RE: ENGINEER CERTIFICATION FOR FINANCIAL GUARANTEE RELEASE ON
PHASE I & II WINDSOR ESTATES (H10-D13) CERTIFICATION
STATEMENT DATED 8/9/96.

RE: REVISED DRAINAGE PLAN FOR TRADITIONS SUBDIVISION PHASES
1 & 2 (H10-D13) PHASE I, ENGINEER STAMP DATED 6/28/95
PHASE II DATED 7/27/95.

RE: REVISED DRAINAGE PLAN FOR TRADITIONS SUBDIVISION (H10-D13)
ENGINEER'S STAMP DATED 5/3/95.

RE: DRAINAGE PLAN FOR TRADITIONS SUBDIVISION (H10-D13)
ENGINEER'S STAMP DATED 2/28/95.

TITLE: **WINDSOR ESTATES
PHASE ONE
GRADING PLAN**

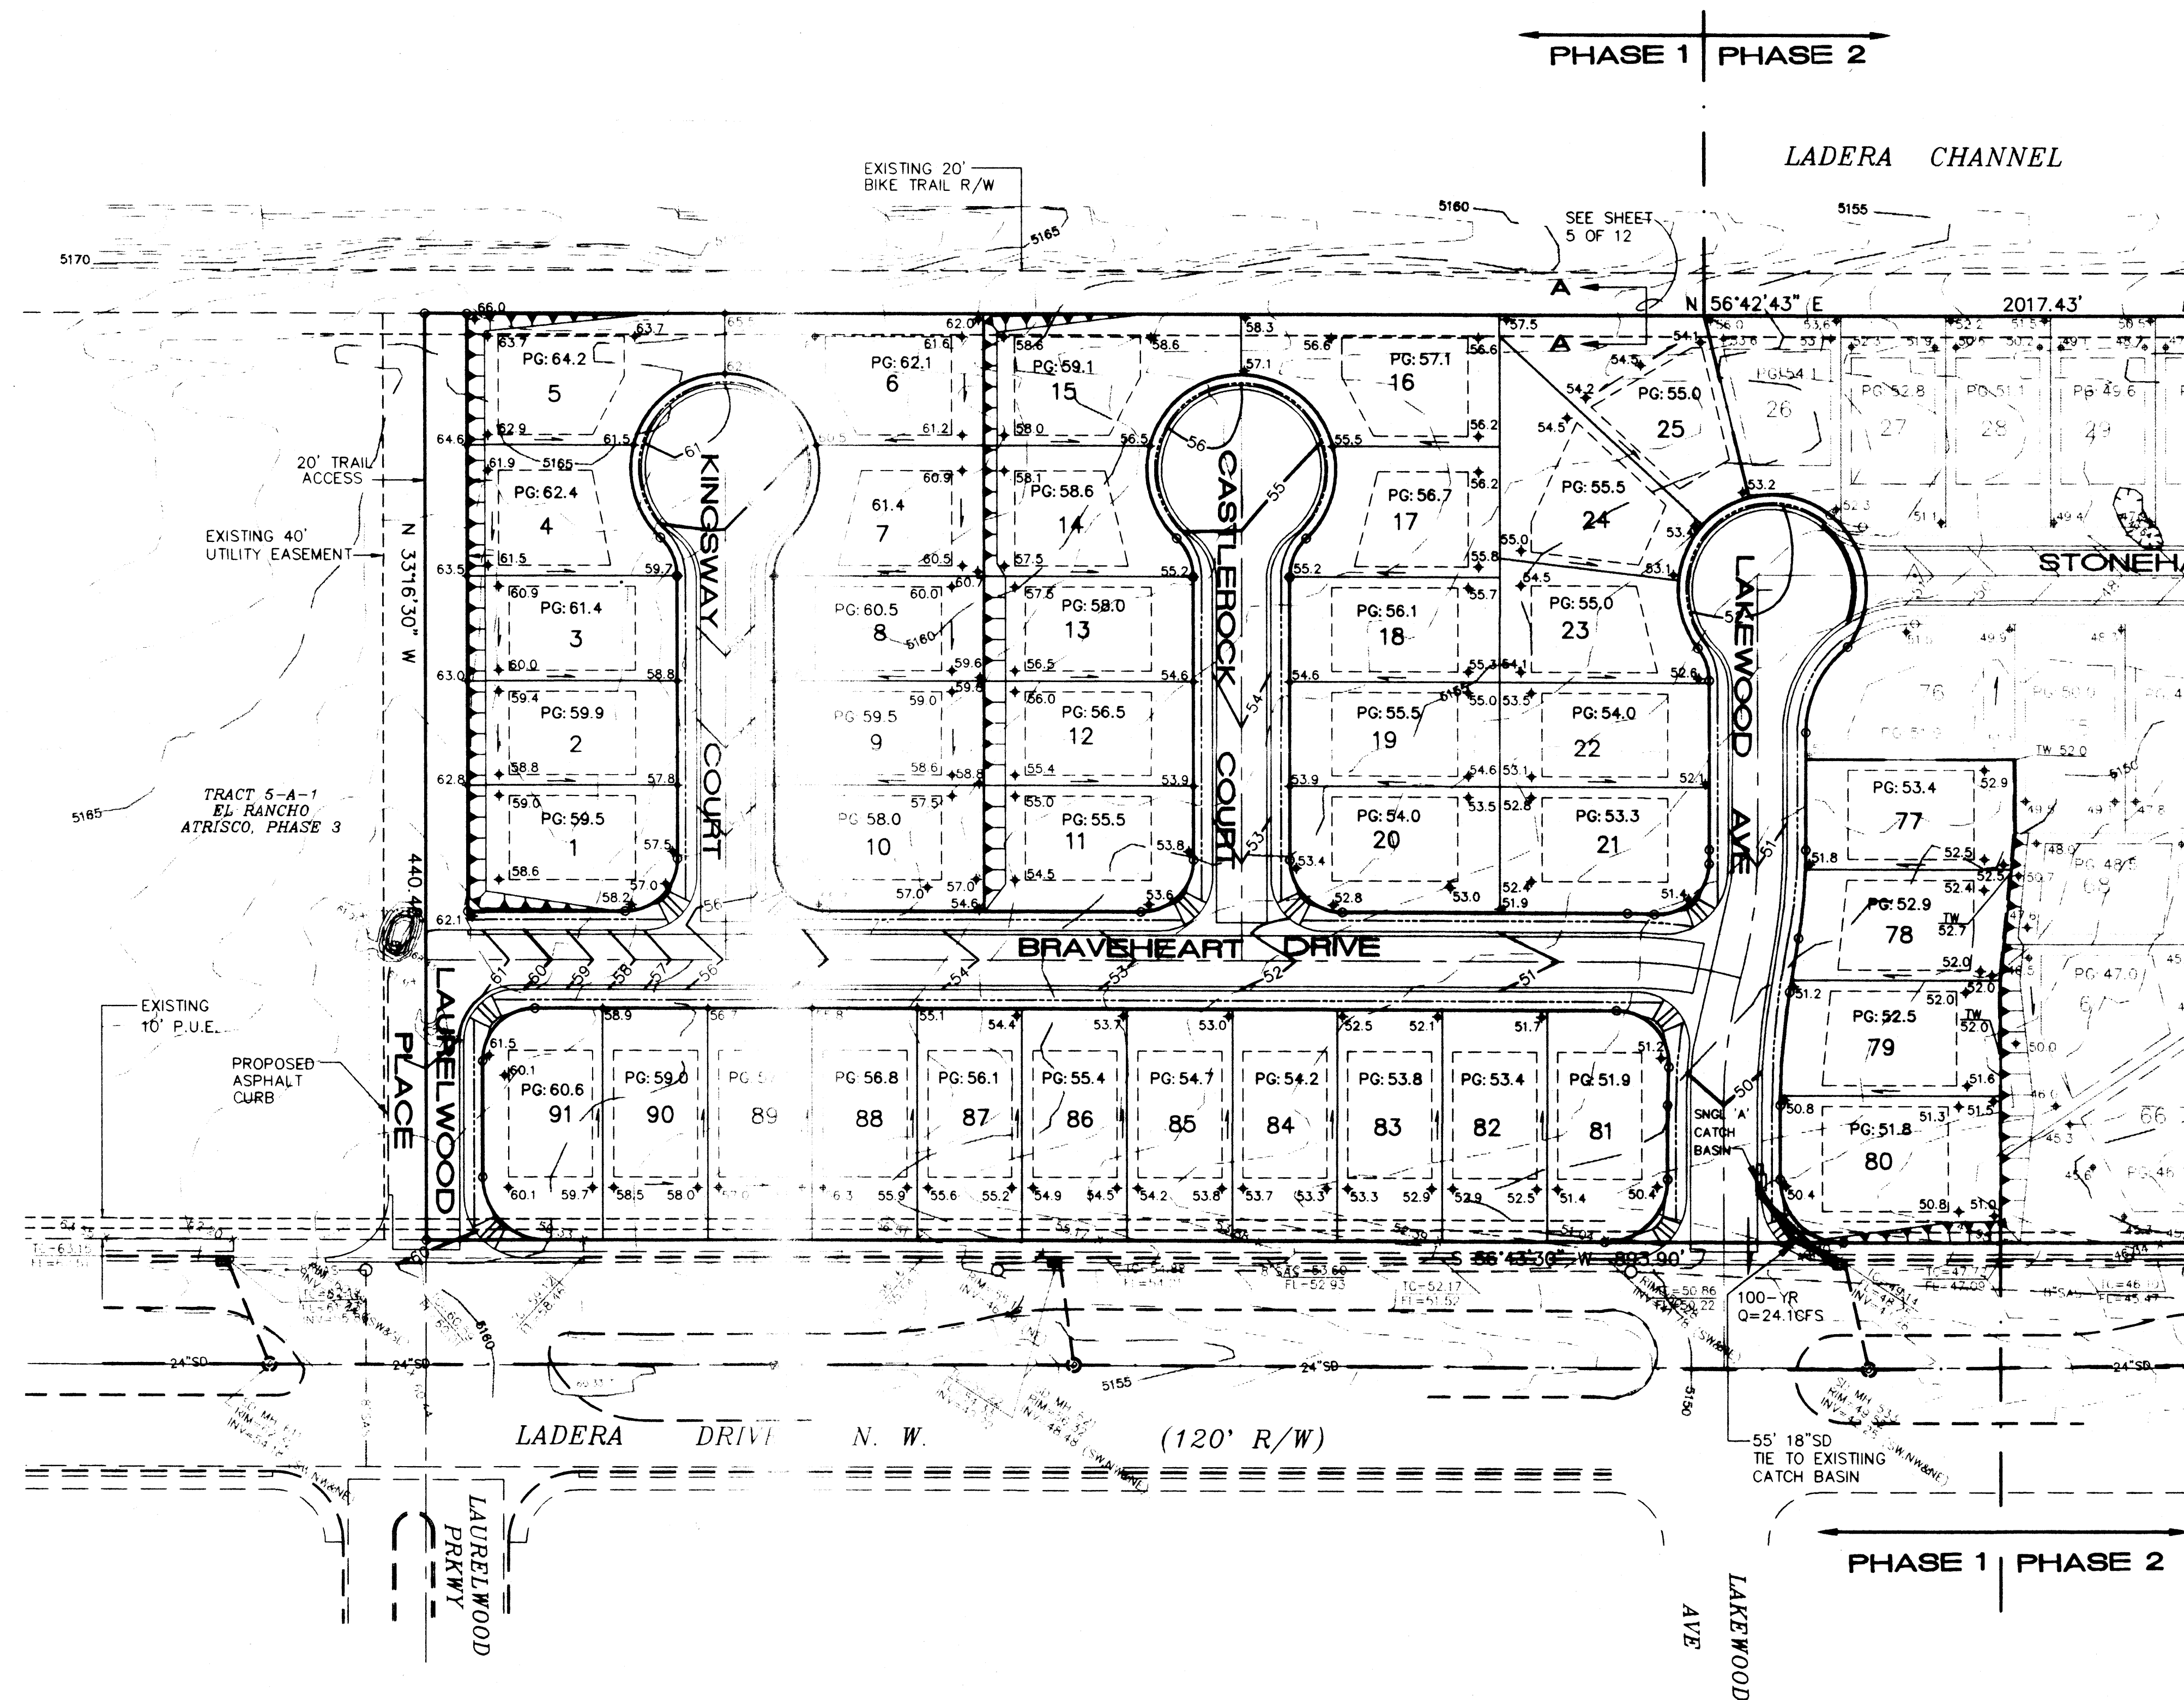
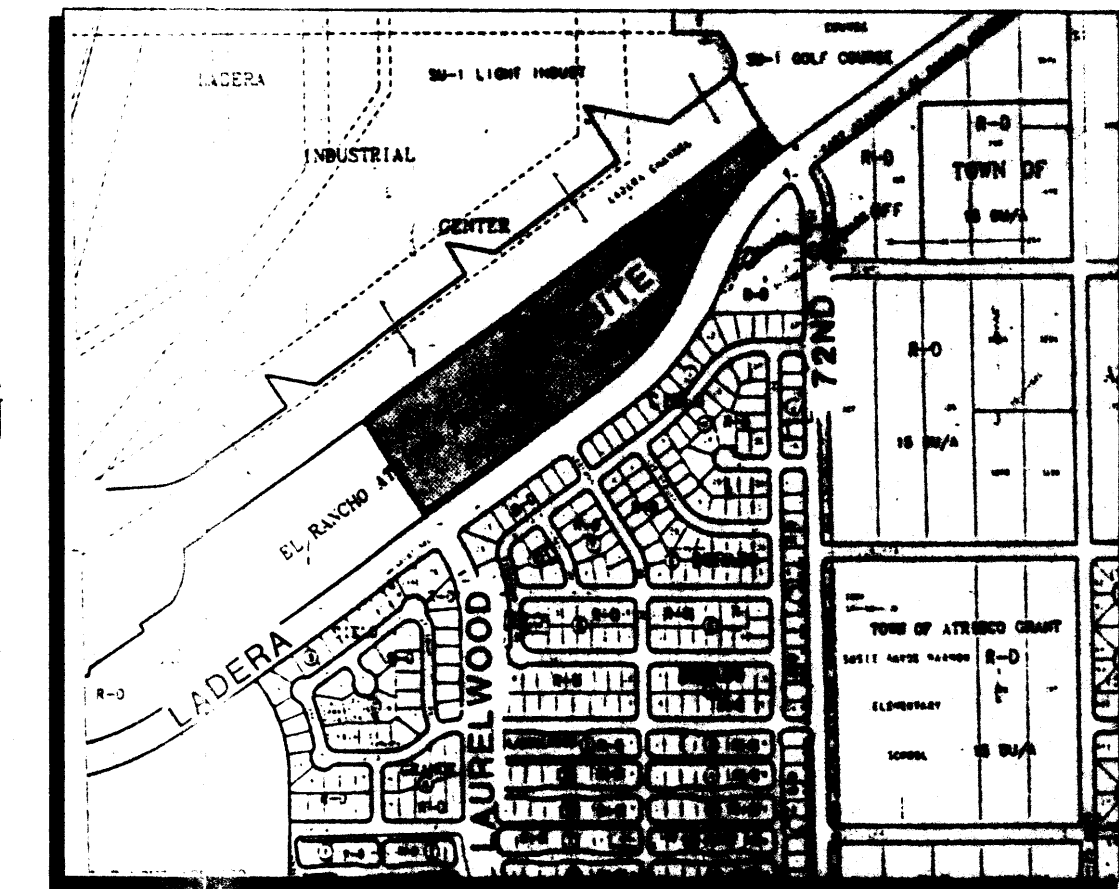
1. Address how you will route the off-site run-off from the
north along the bike trail. concurrence from Parks and
Recreation will be required.
2. Address the capacity of Ladera Sr. NW and what effect the
additional run-off will create.
3. Detail of proposed run down from Brambleberry Place towards
Ladera Dr.
4. Identify which rear yards will drain to street and how.
5. Indicate location of proposed inlets on Ladera Dr. NW.
6. Typical side yard detail to identify how flows from each
adjacent lot will be routed to the front.
7. All developed run-off must be routed out through the drive
pads. Your typical lot design does not indicate this.

TITLE: **▲** *WINDSOR ESTATES
 PHASE TWO
 GRADING PLAN*

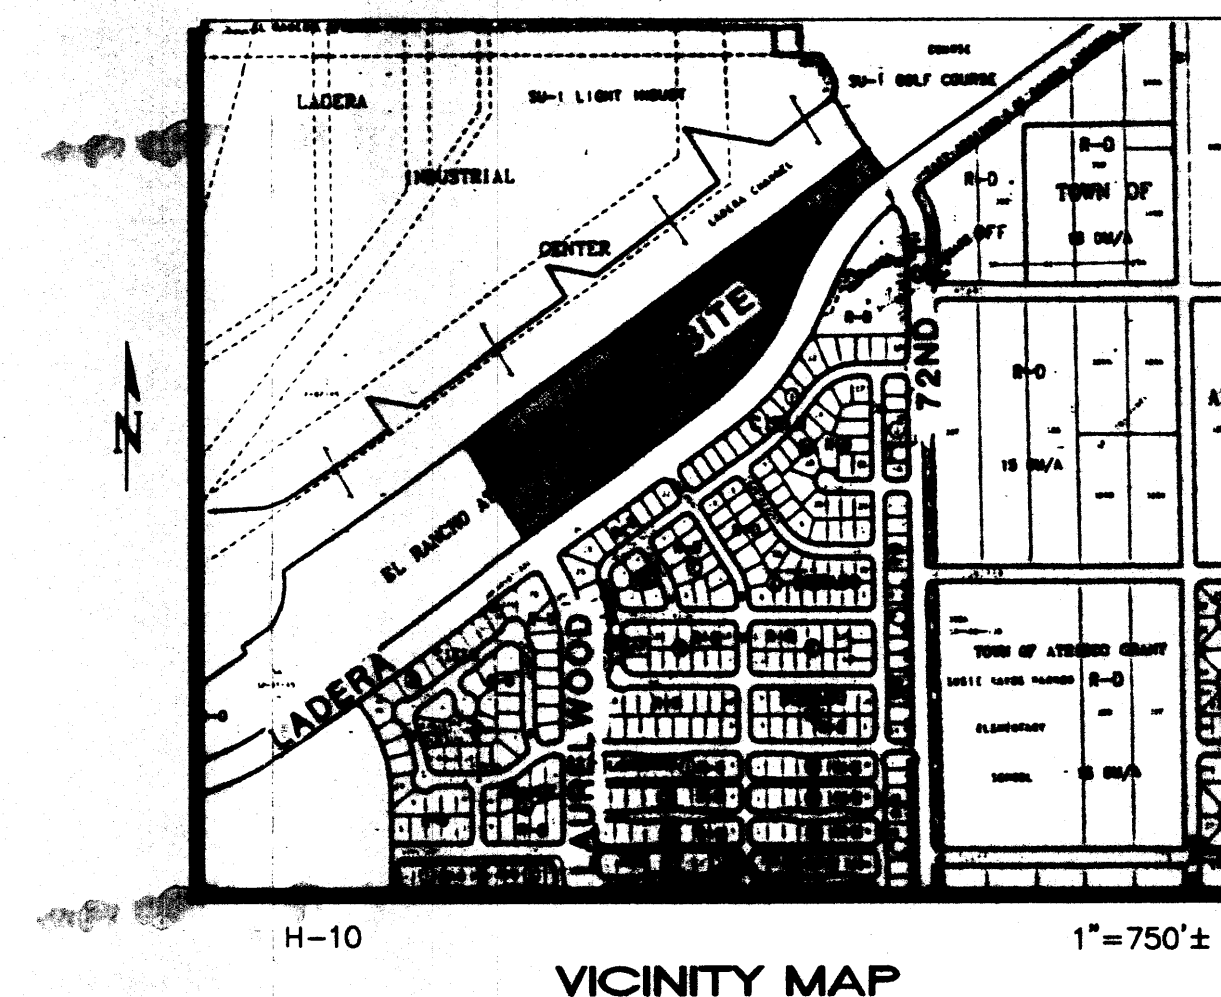
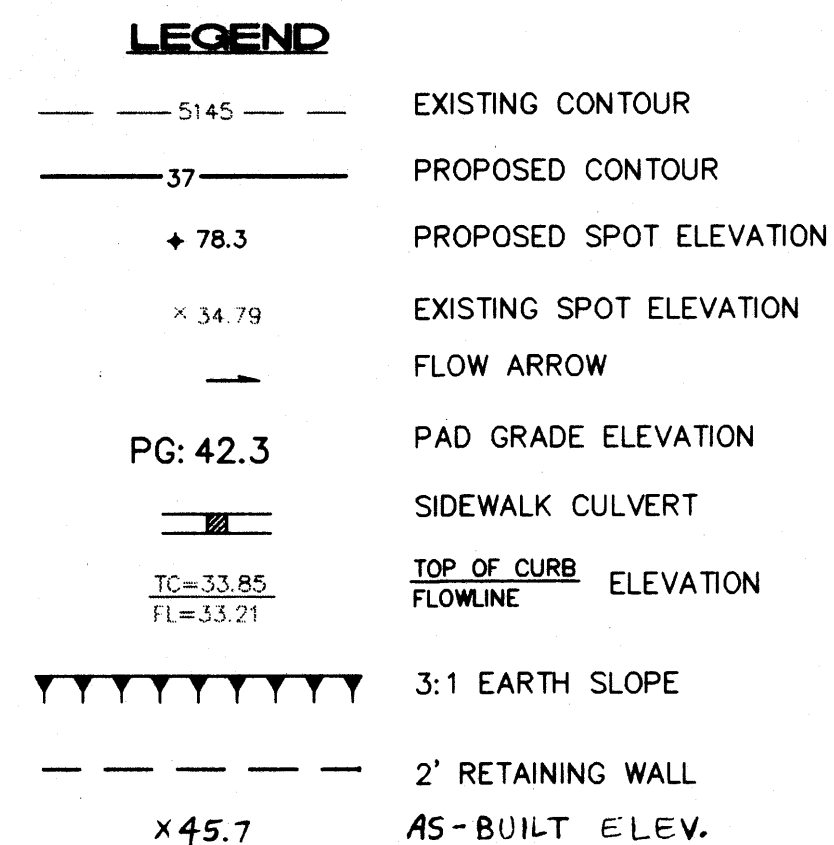
1. Lots 41-43 Phase II must be drained. No retention ponds are allowed per Ordinance.
2. Additional information along with a P. & P. of the proposed storm sewer on Ladera Dr. indicate the H.G.L. & the E.G.L.
3. Parks and Recreation has a concern on vehicular and pedestrian traffic on the lots adjacent to the bike trail Right-of-Way.
